BEACON LITE ROAD STOCKPILE – FDR AMENDMENT 1:

COMMENT RESPONSES

September 8, 2026

D1
sheet number

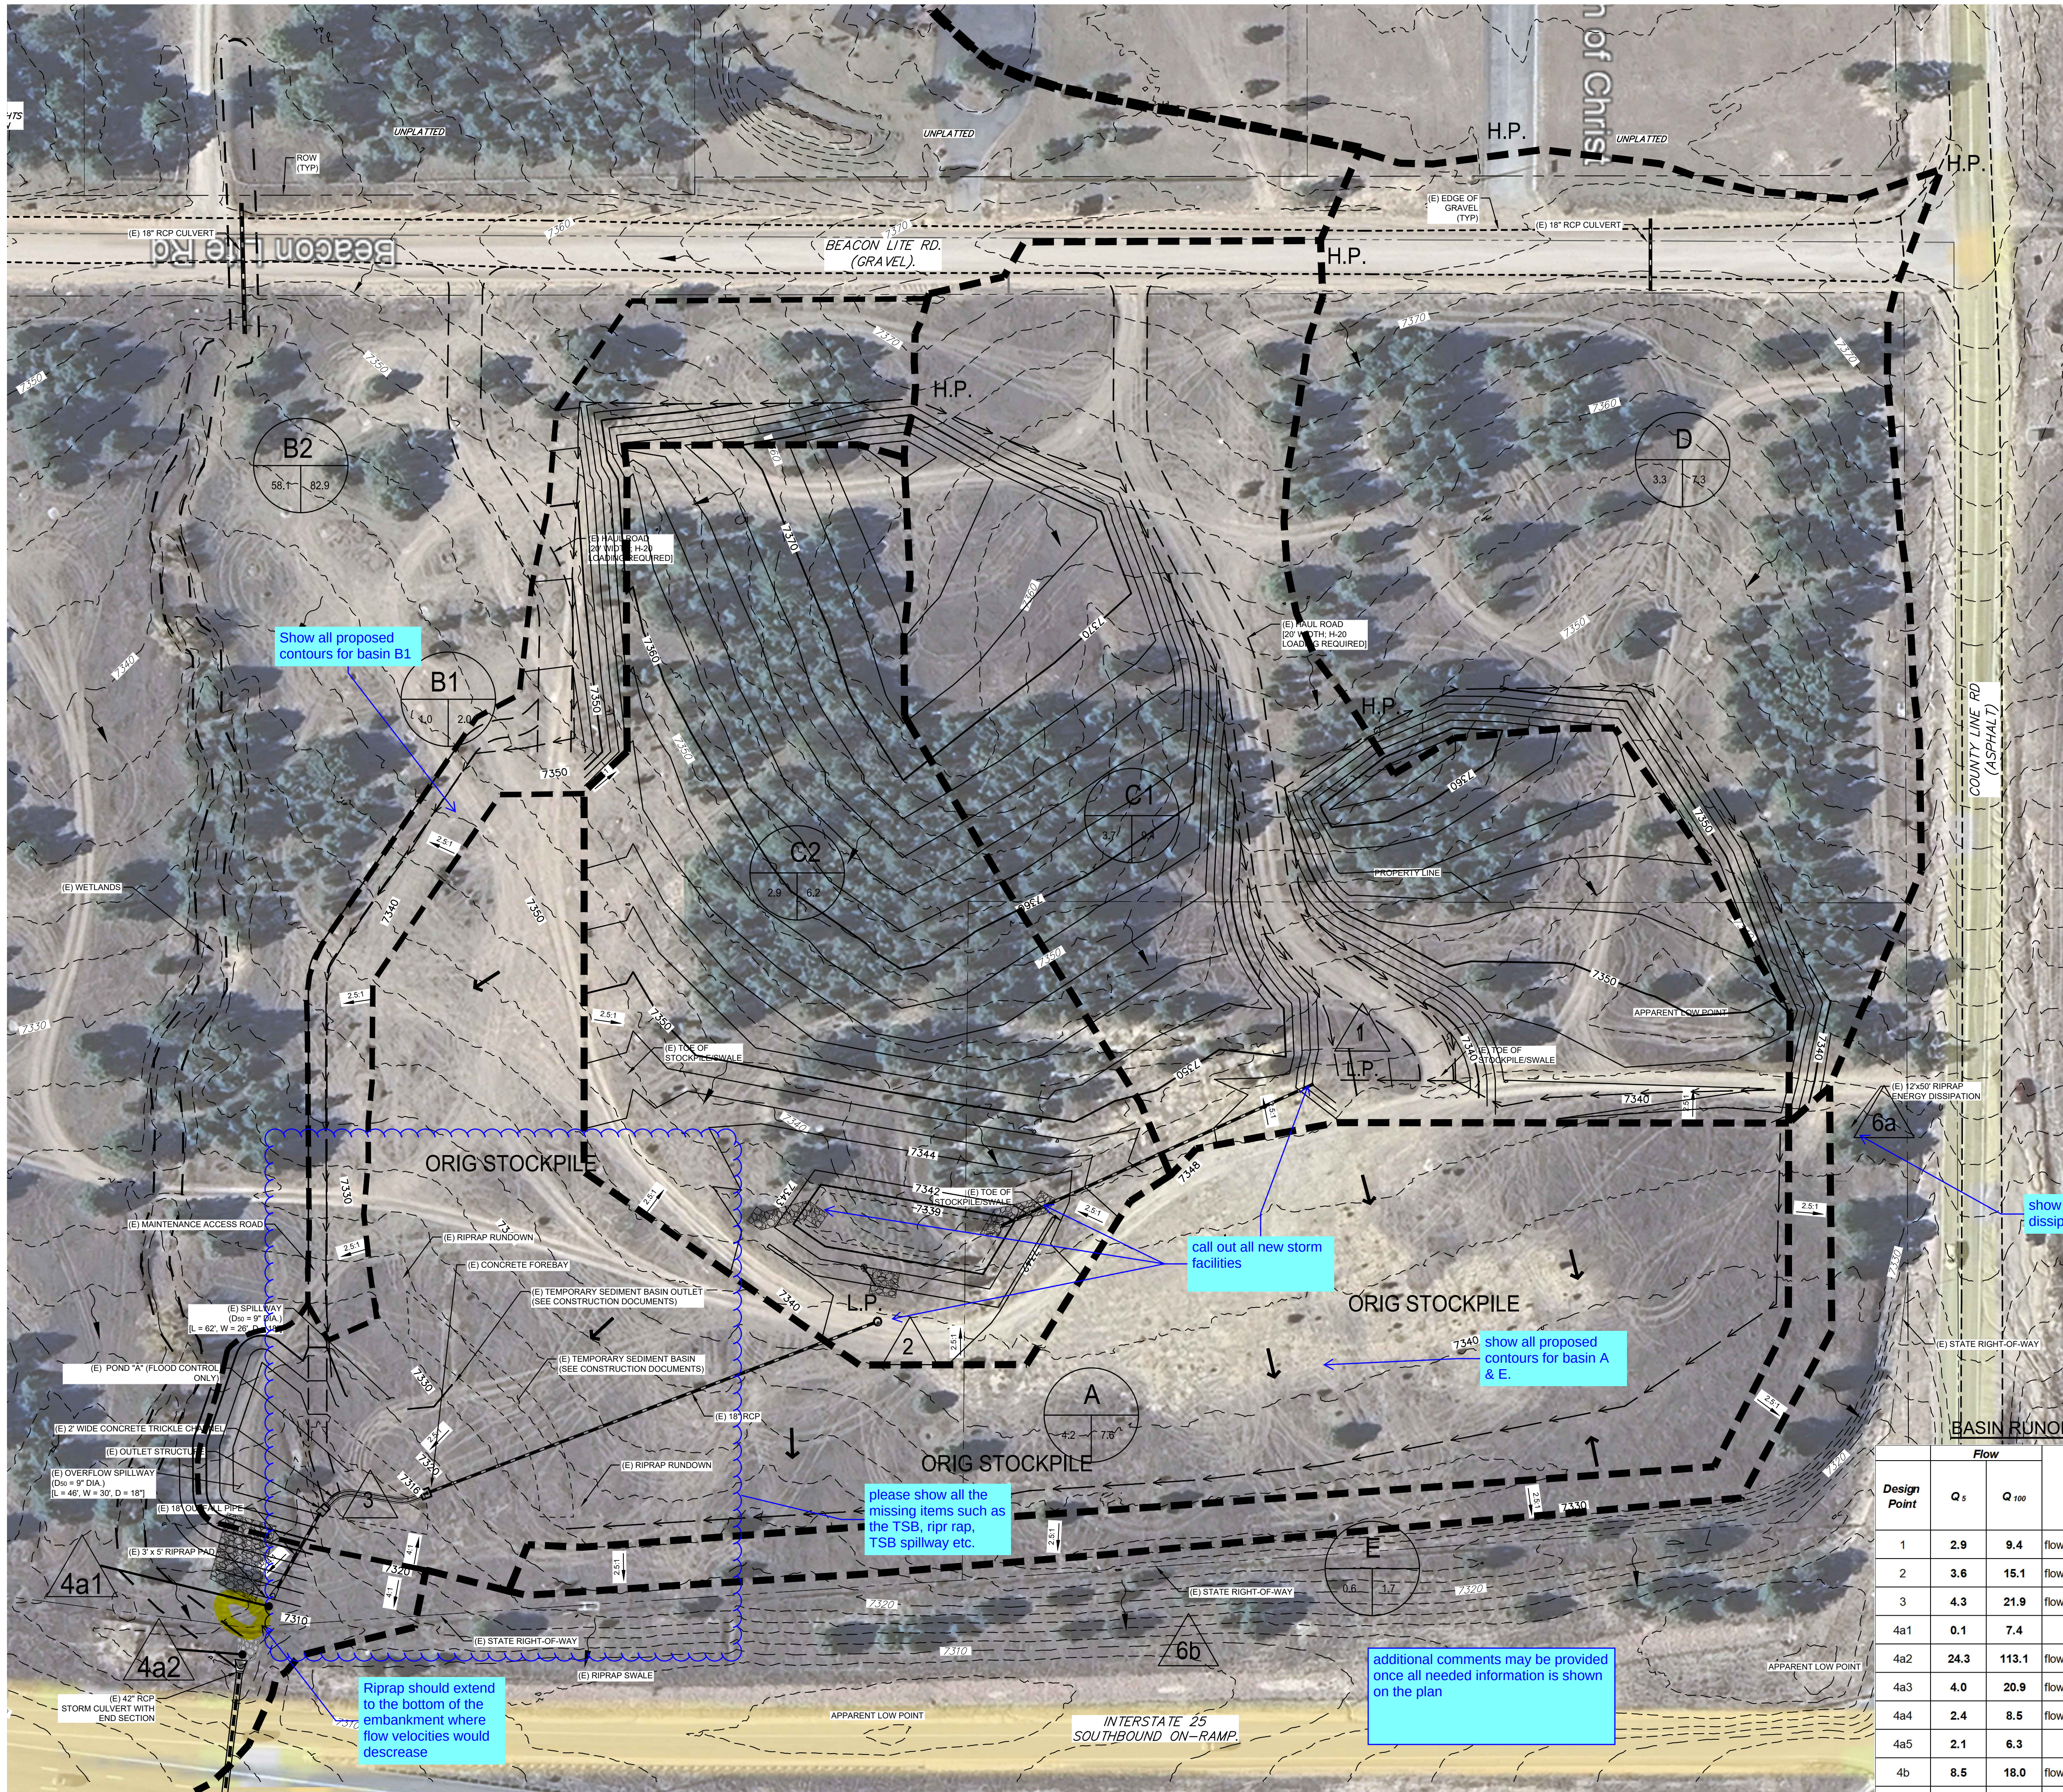
119	Per the narrative, the existing conditions map is intended to reflect the original proposed conditions. Please update the drainage map to reflect the contours of the original proposed conditions. Drawing updated to reflect existing conditions grading which has occurred.
119	provide a leader pointing to the basin See map for leader addition.

PDF page	Comment
119	provide a leader pointing to the basin See map for leader addition.
119	The existing conditions map should be kept as existing (historic) conditions without the addition of the previously proposed work. See comments on the drainage report. See prior comment response related to this issue.
120	This existing basin should be broken up to better compare with the proposed work to be done within this basin. This map, similar to the other prior approved maps, have been relocated in the Appendix so they are separate and create less confusion.
122	provide complete basin delineation of Basin B2, B3 and B5 A basin line between B3 and B2 was missing and has since been put on the plan. Basin B5 is the pond itself.
123	make note larger and/or different color so that it stands out. Recommend keeping all original sheets together in an appendix to avoid confusion. See revised plan for bold and red text label. The approved plans have been located in the appendices separately now.

◆ DRAINAGE PLAN.
PROPOSED CONDITIONS - OVERALL

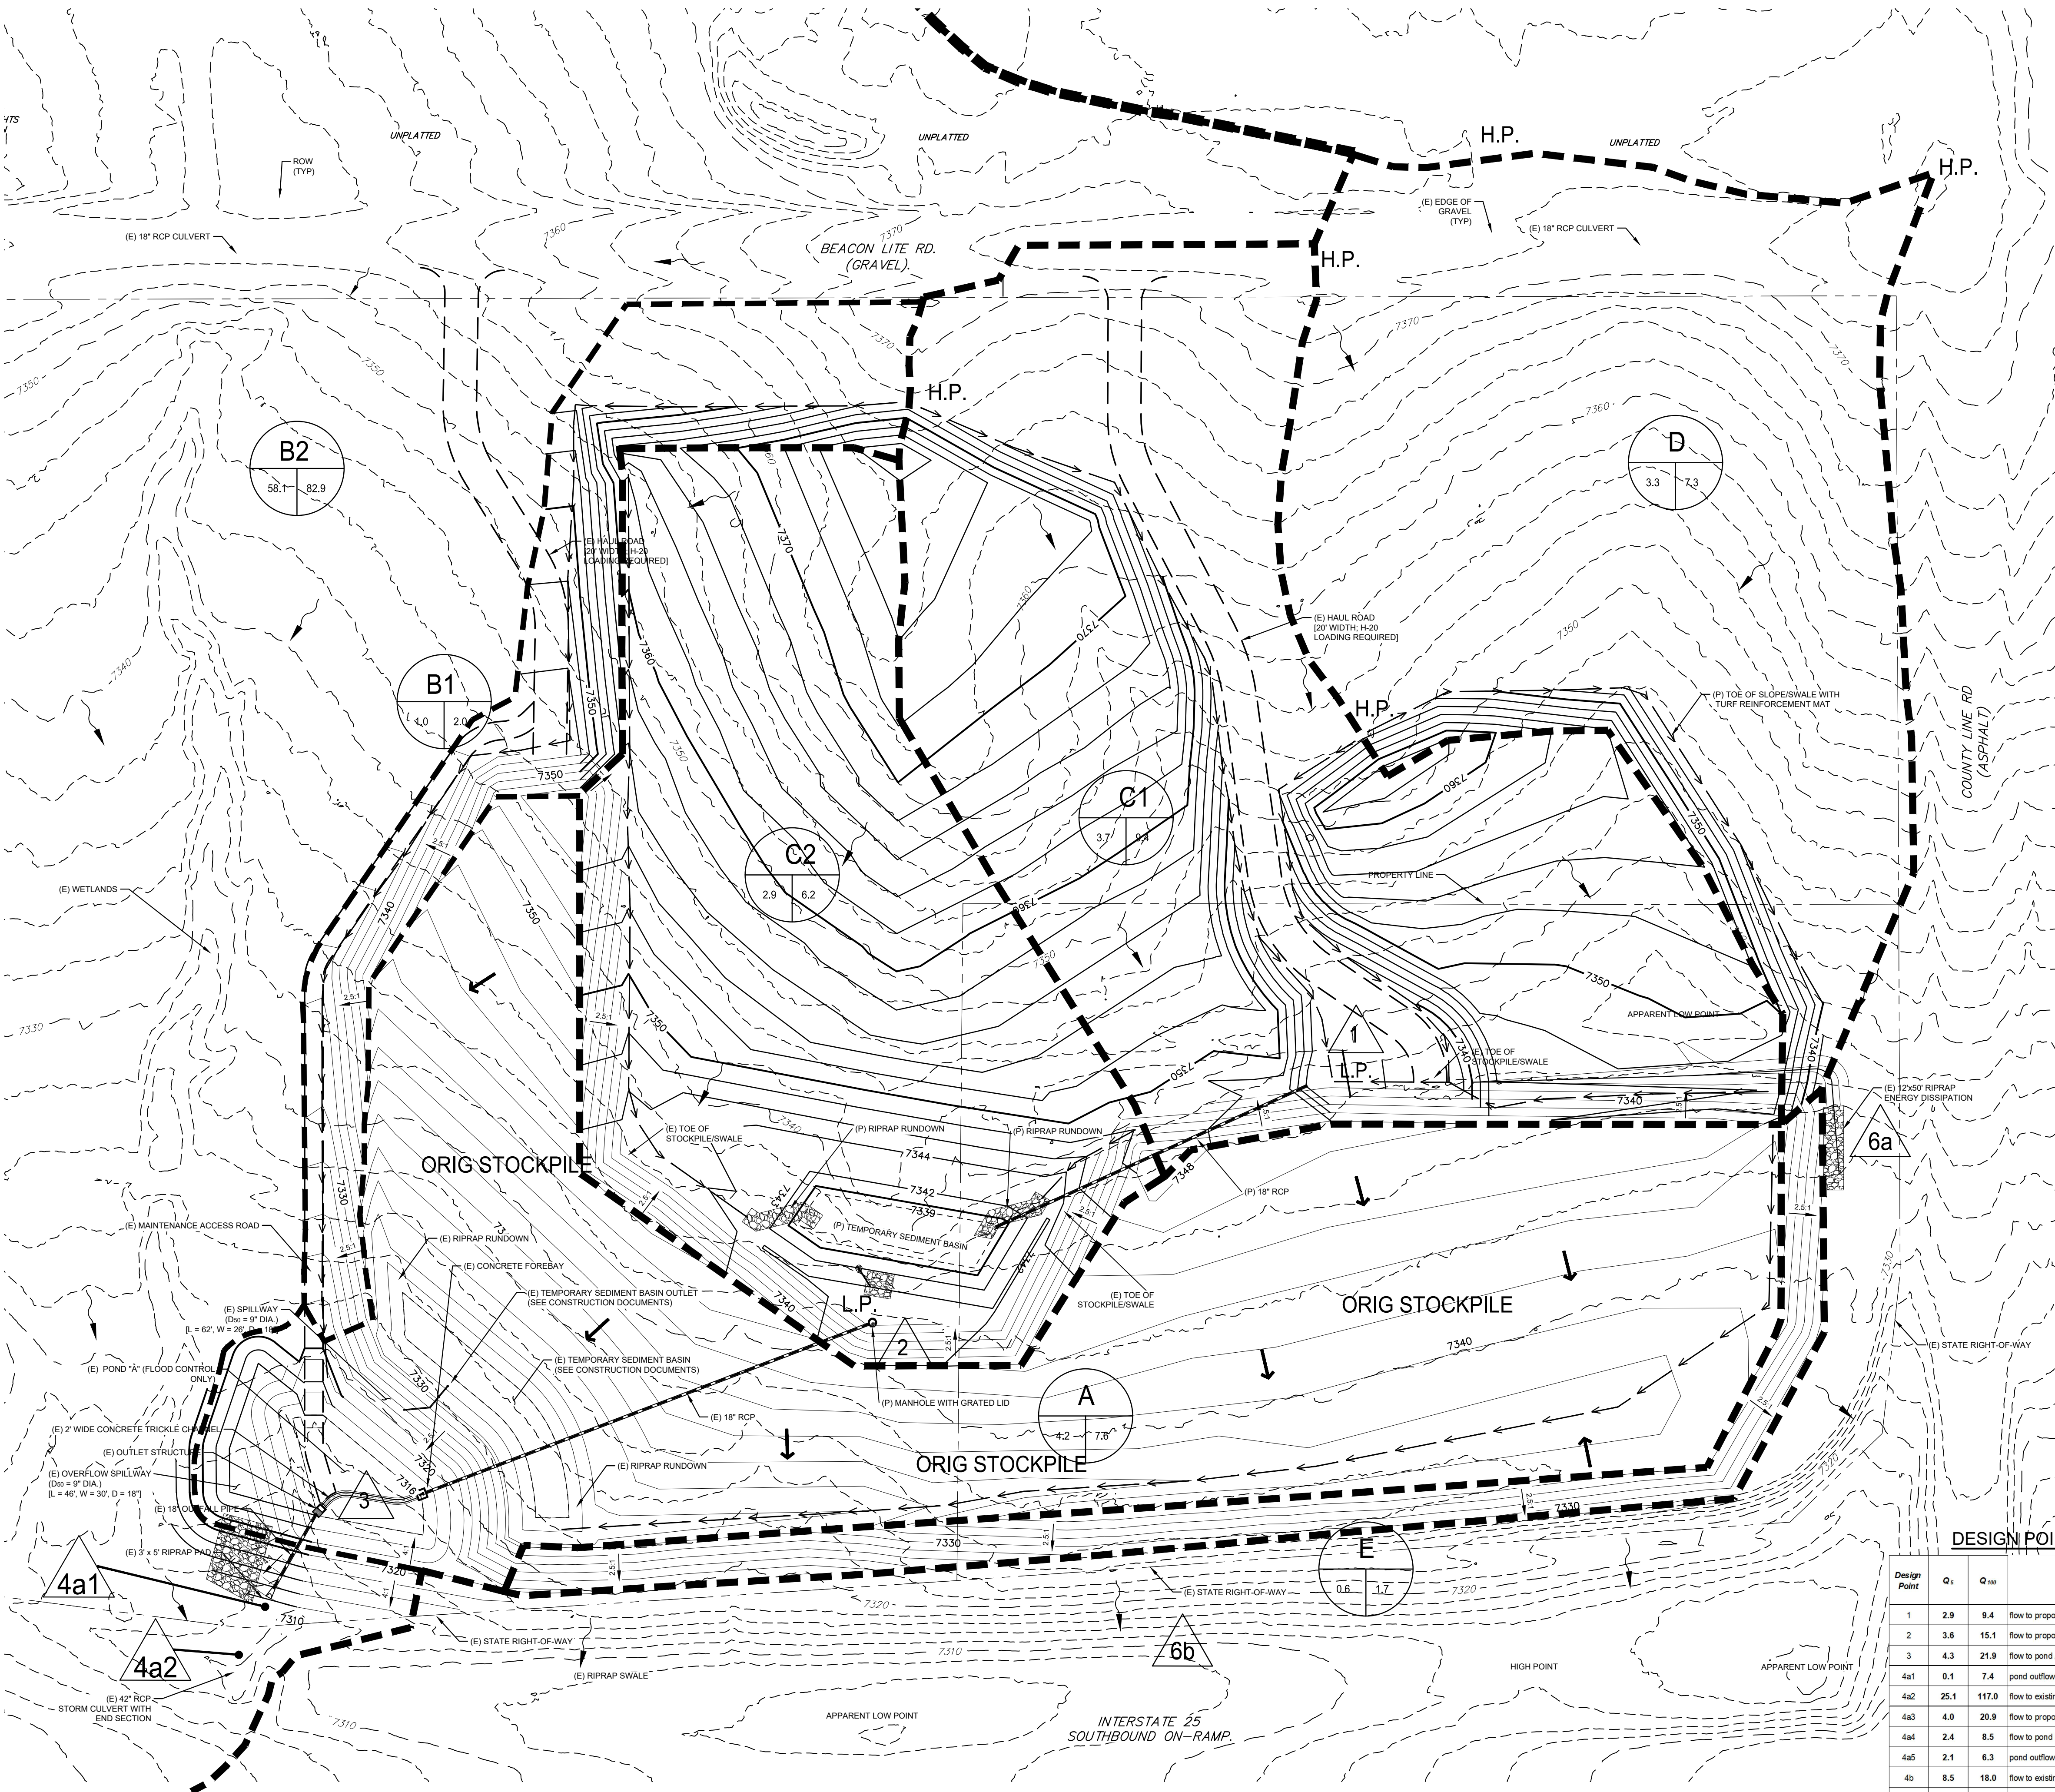
9	no table provided. Are you intending to provide a table of the new existing conditions vs the historic conditions? Refer to Proposed Conditions narrative.
9	4a1 was the pond outfall which had flows from A, B1, & C (X1, X3, X2a) revise accordingly. This has been revised accordingly, as the pond outfall location.
9	flows do not match the drainage map for X2a (B1), revise. N/A – this sentence has been removed. See revised narrative from prior comment.
9	previous report has design point 4a2 as Q5=24.6, Q100=116 cfs. The flows at this design point have been revised to match the prior approved report.
9	not shown on the existing drainage map. Please show This is shown on the Proposed “Overall” sheet.

14	show design points on the main proposed drainage plan. See map for Design Point label additions.
